DESIGN AND ACCESS STATEMENT IN RESPECT OF
PROPOSED RESIDENTIAL DEVELOPMENT ON THE SITE OF BARNSELY FOOTWEAR DISTRIBUTERS LTD.
3 LANGDALE ROAD BARNSELY

Residential development Langdale Road/Avon Street Barnsley

PROPOSED SITE LAYOUT 1:500.

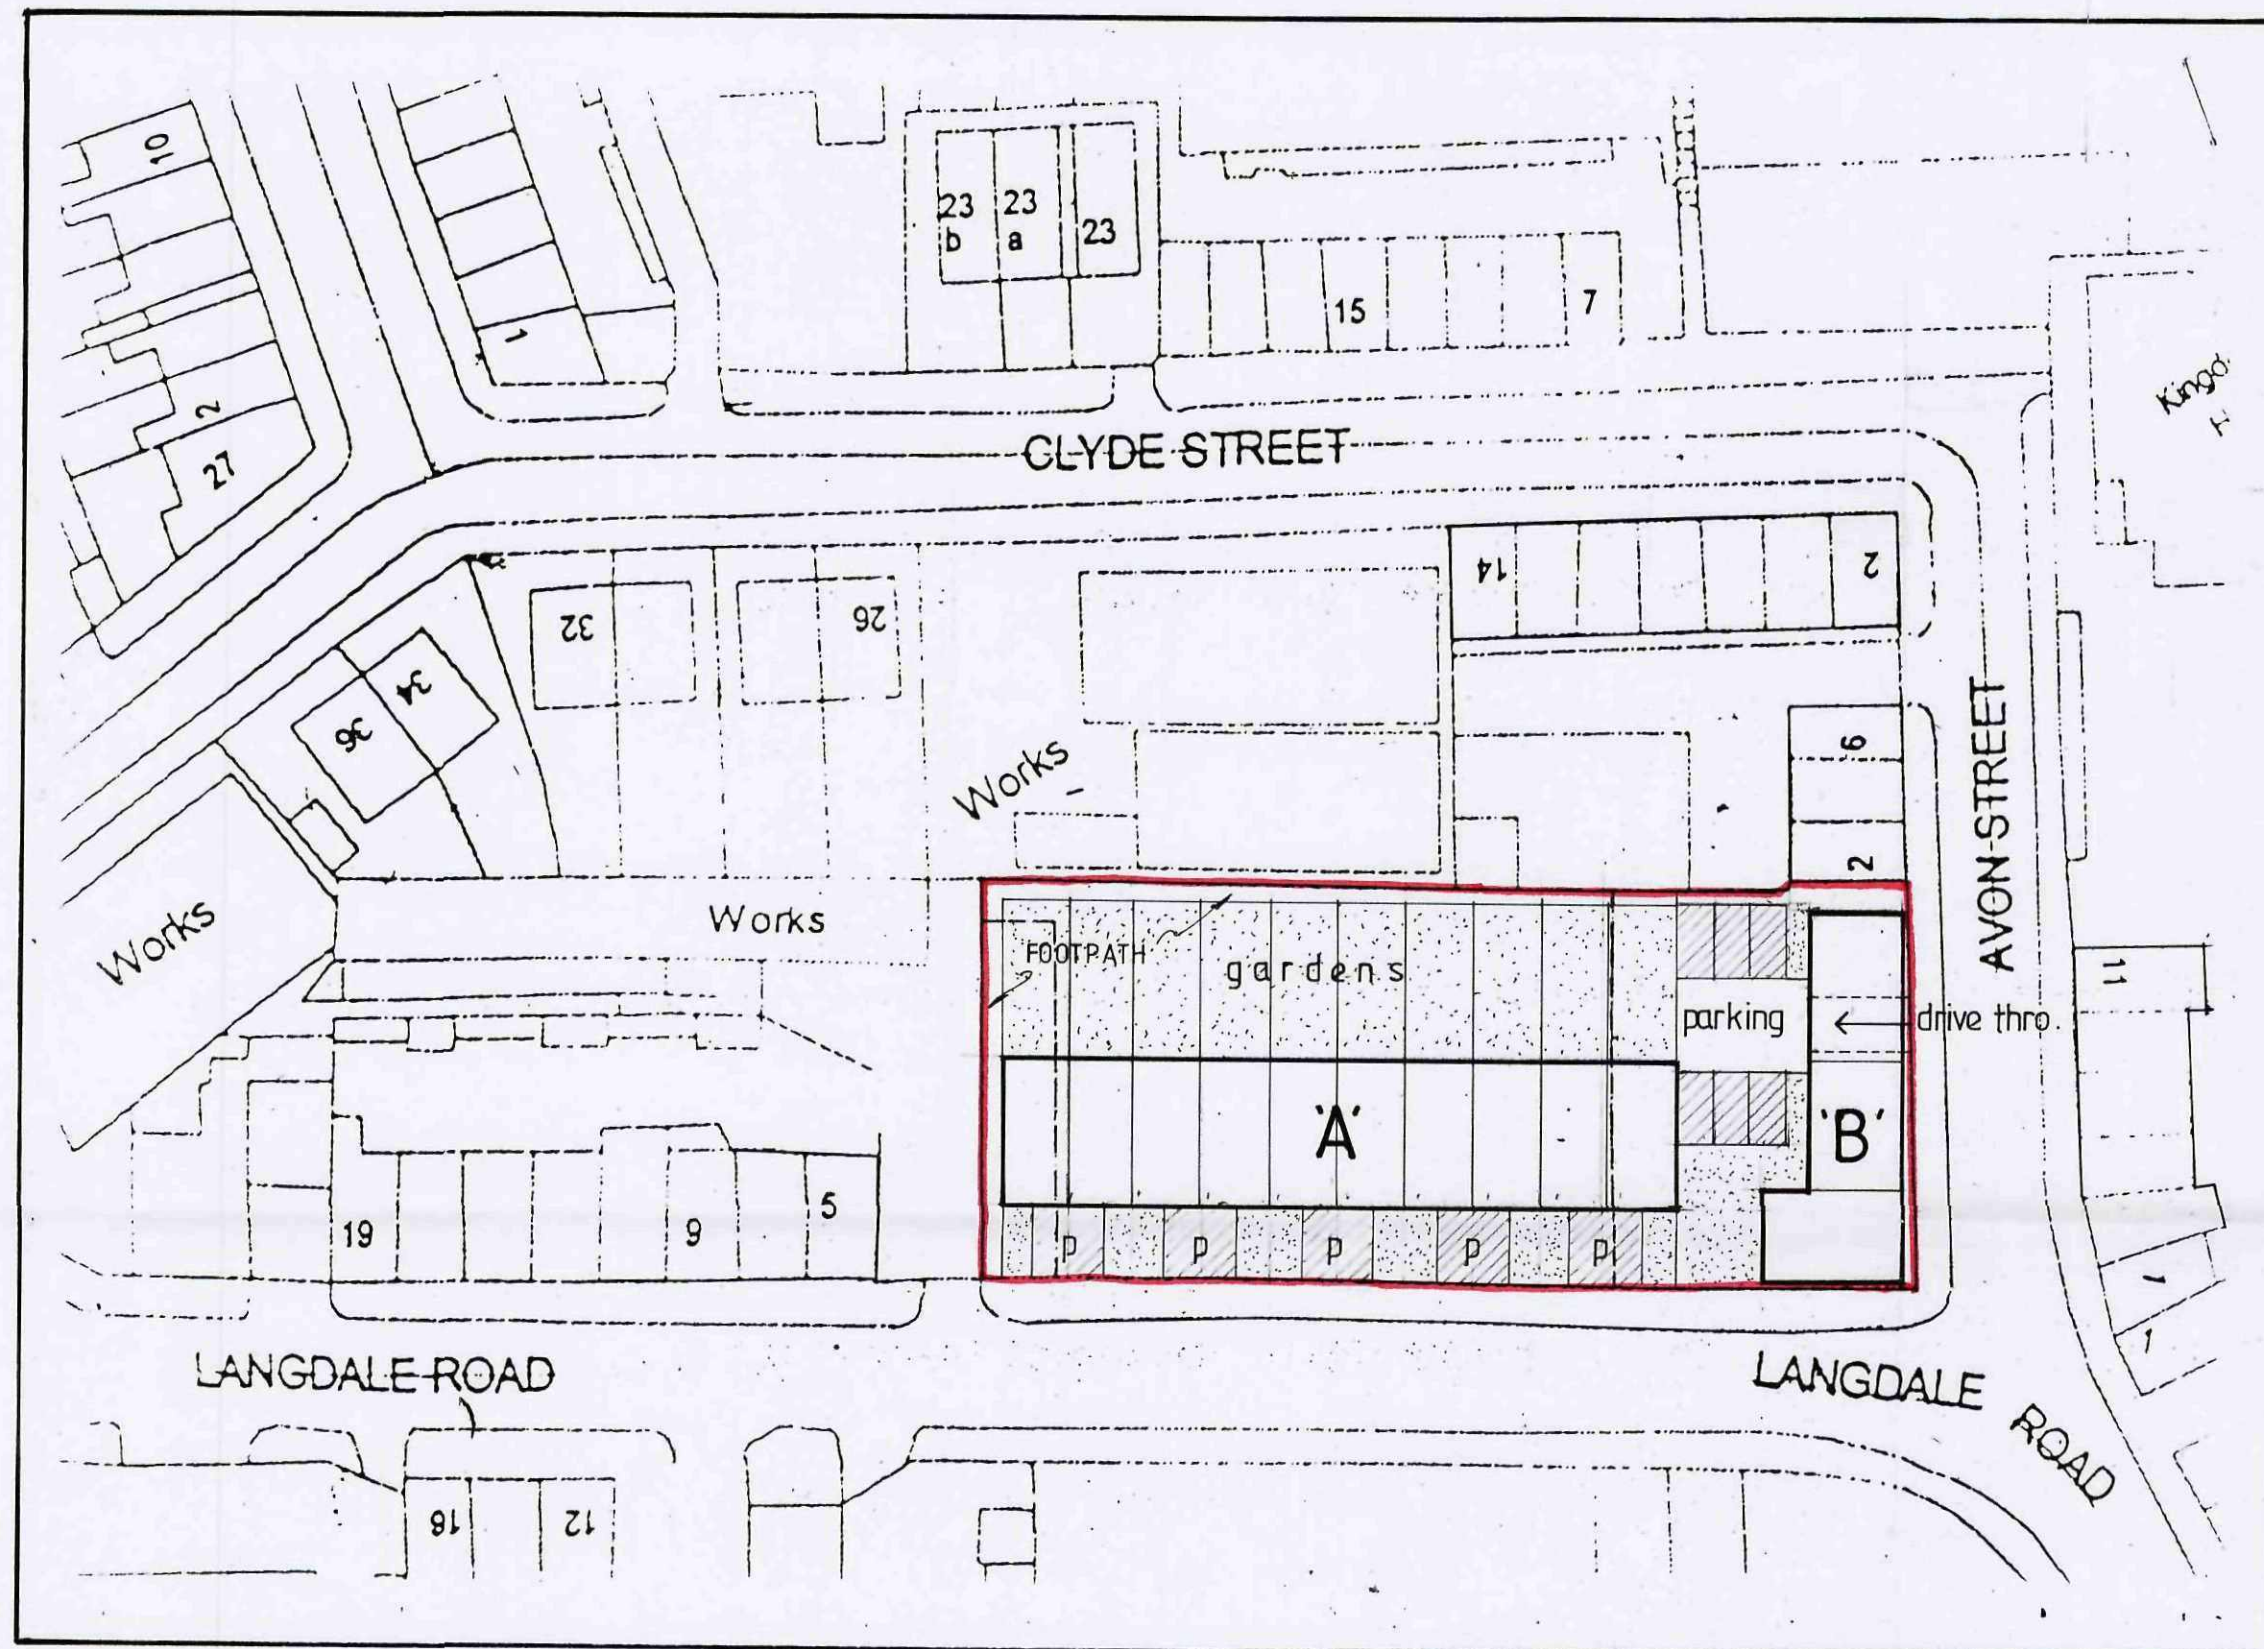
I refer to the above query and would advise you that in principle residential development is an acceptable use for this site, subject to compliance with the Council's Development Control standards. Bearing in mind the adjacent two storey properties it is considered that the maximum height of any new development should be two and a half storeys. Frontages immediately on to the back of the footpath would be acceptable.

The idea of a rear access is not viewed favourably, as vehicles could find it difficult to reverse and would be more likely to park on the street. It is unlikely you will achieve the number of units shown on your sketch. It is suggested a small garage court or parking area may be more acceptable than rear access, or a mix of houses with drives and ones with parking to the front.

Parking provision should be at the rate of 1 per unit if flats, 1.5 per unit if houses.
